**ADC Planning Consultation
Response from the Conservation Officer**

Application Number	R/77/14/PL
Address	Church of St Peter & St Paul Rustington
Description	Extension to south side of church. Resubmission of R/188/13/
Case Officer	Anita Gardner
Site Visit	12 February 2014

REORDERING & EXTENSION:
ELEVATIONS AS PROPOSED

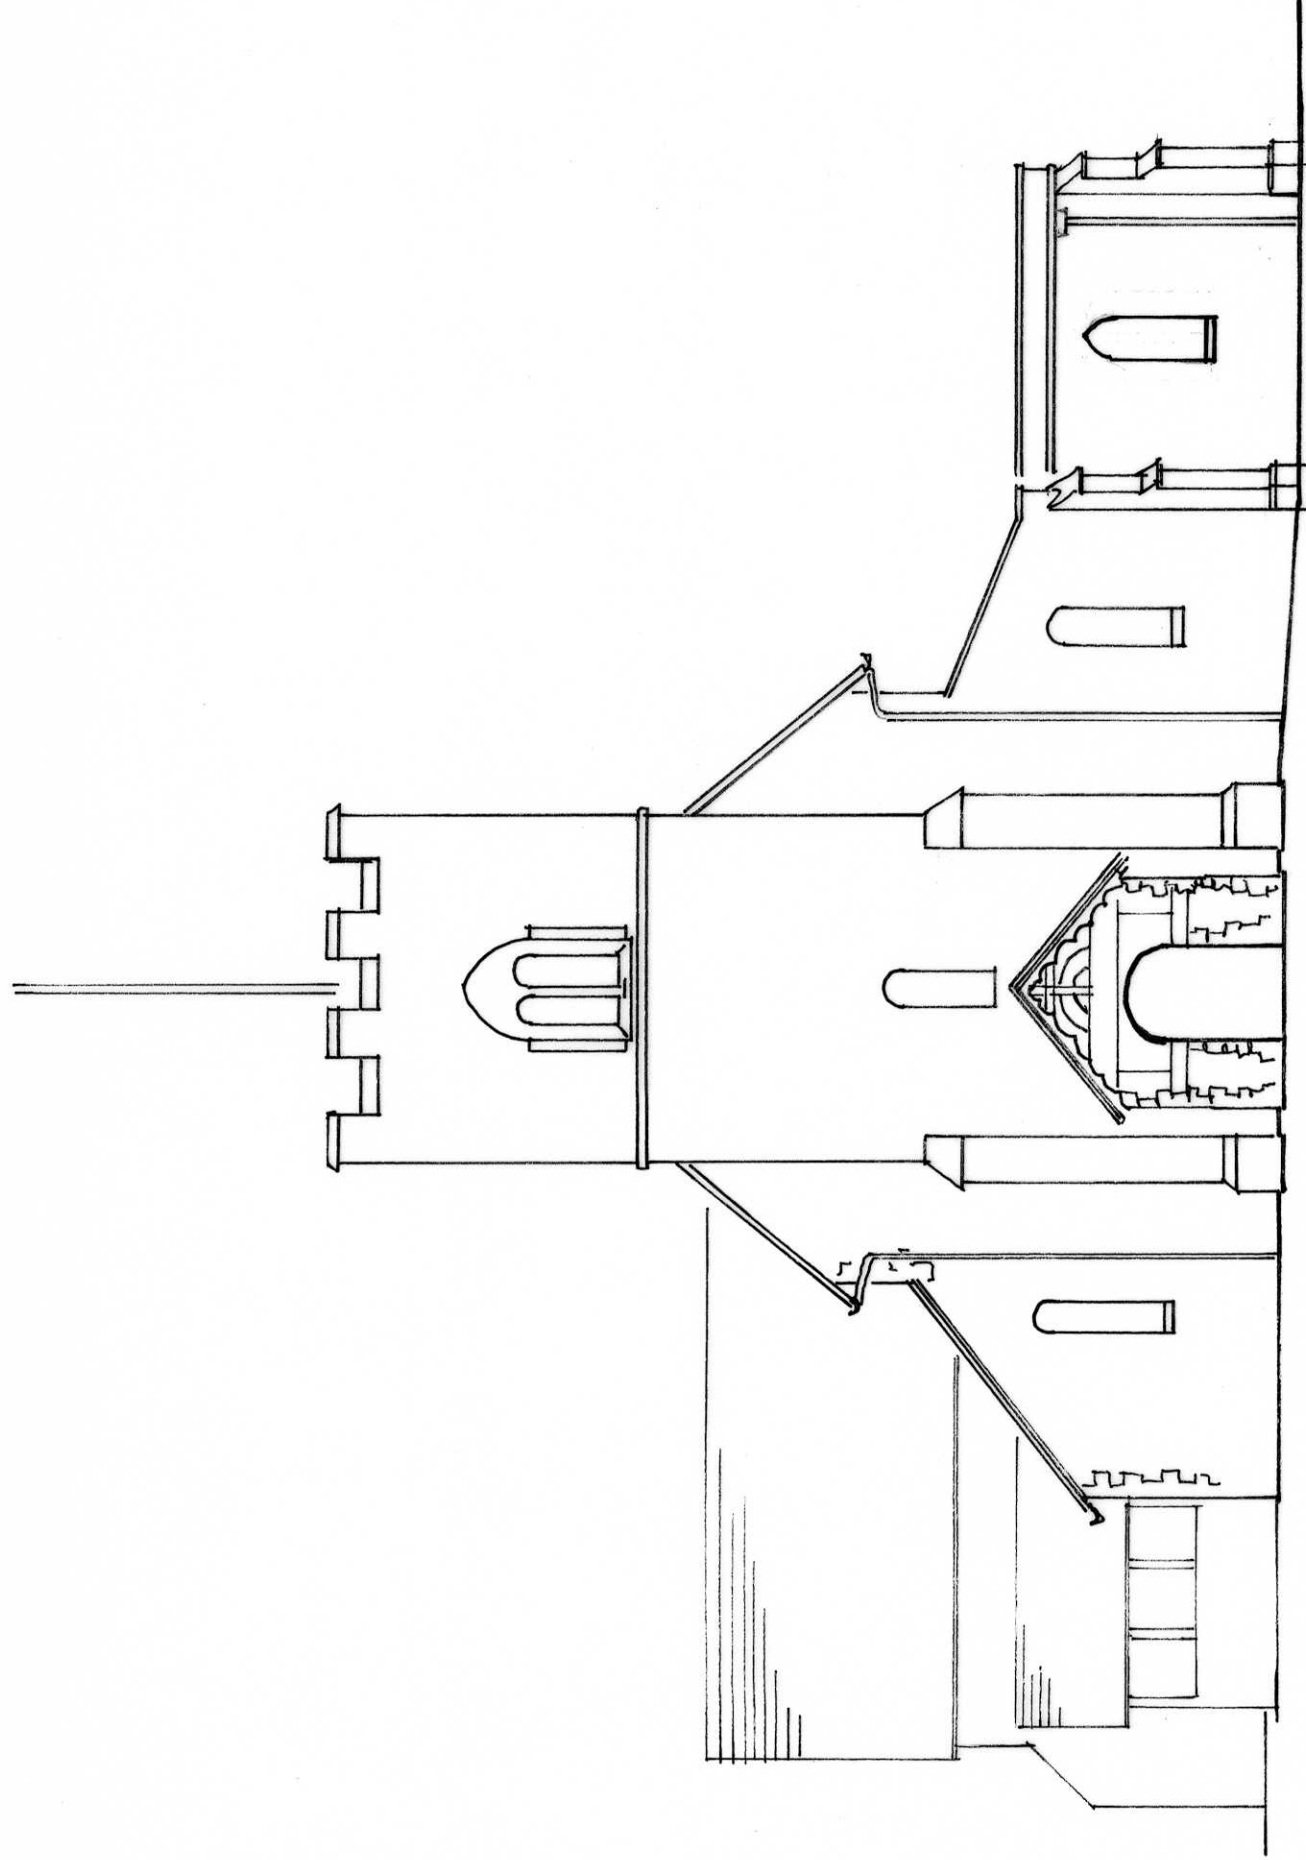
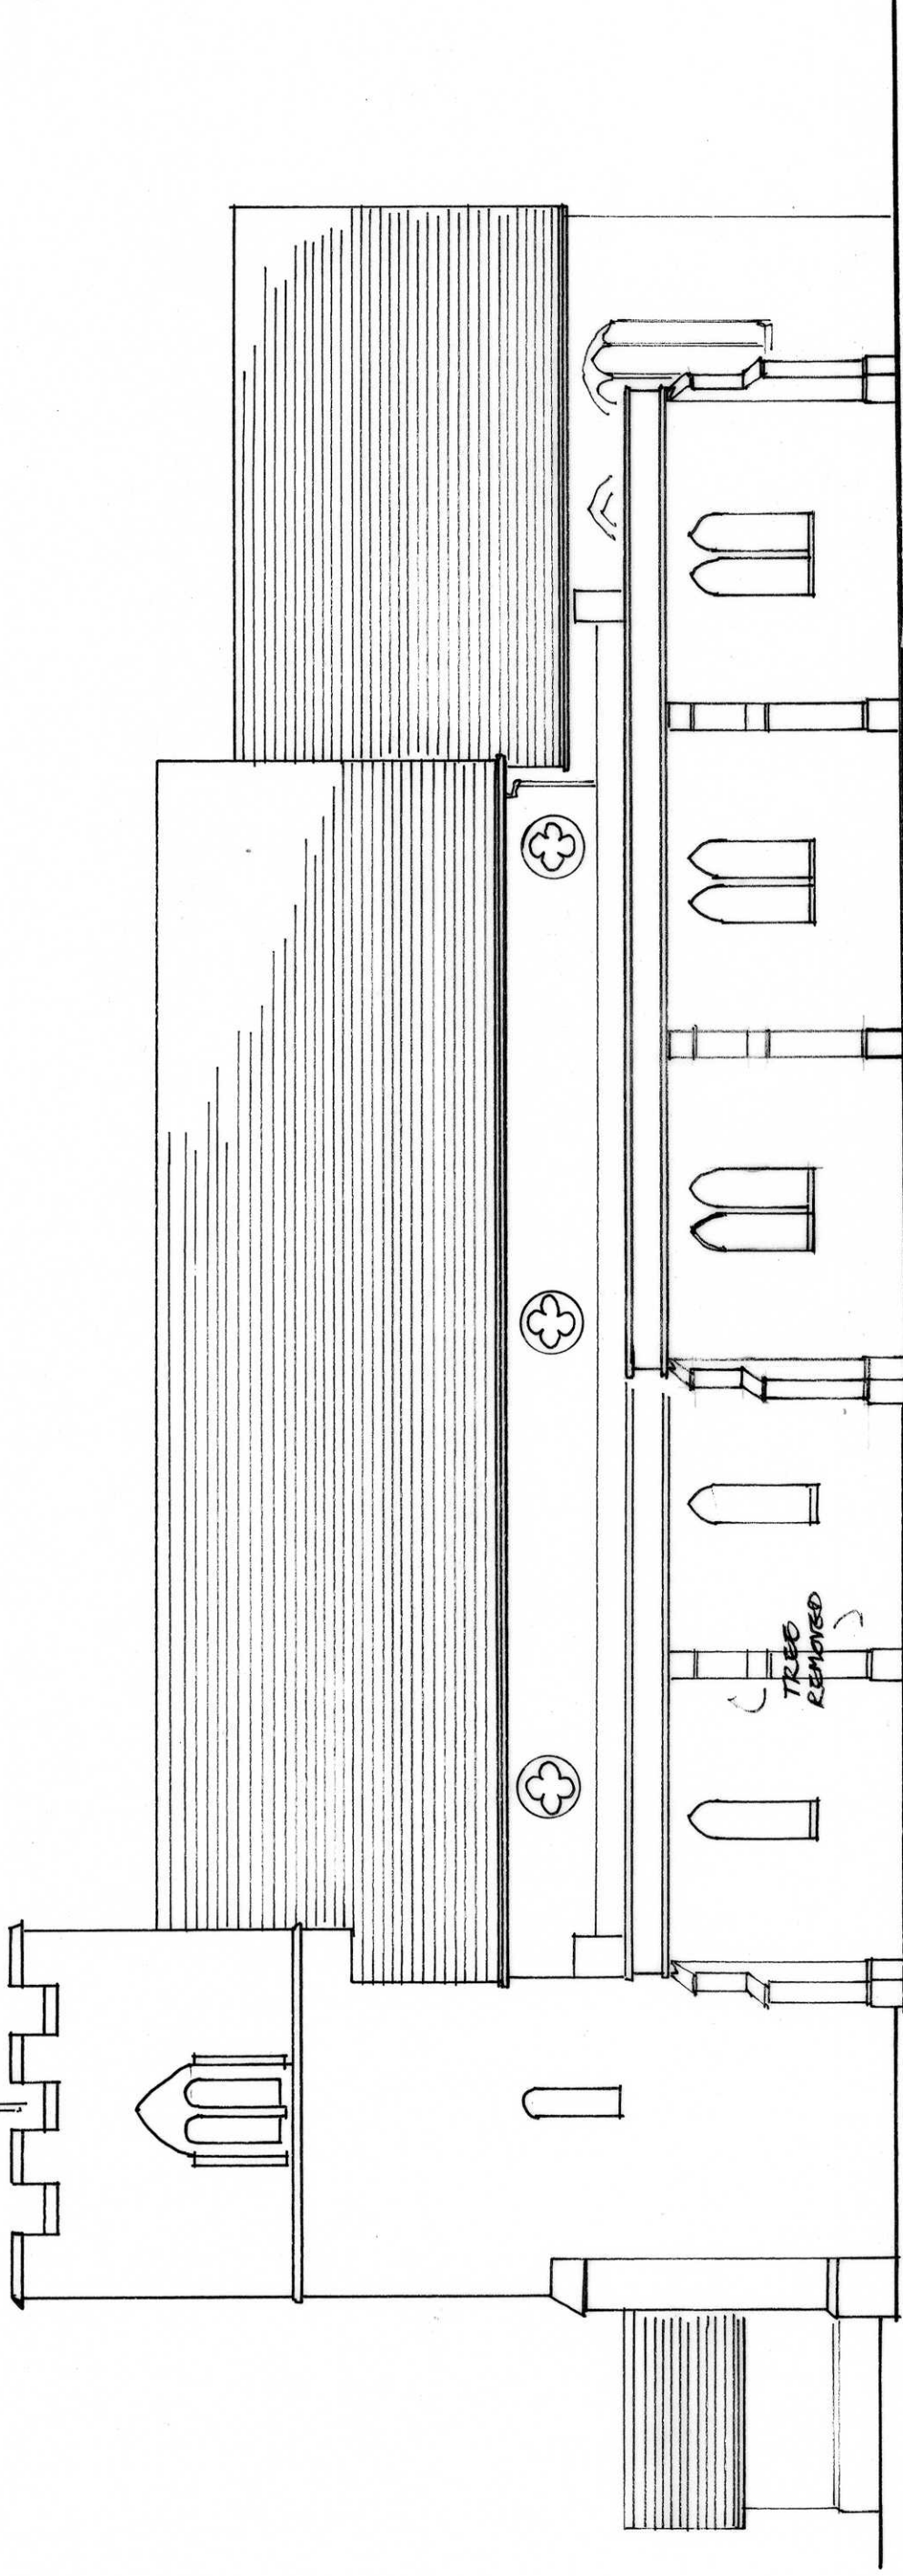
The proposed works are now considered acceptable. However, this is subject to the new flint work matching that of the existing. A sample panel of the flint should therefore be conditioned for approval.

Sample flint panel
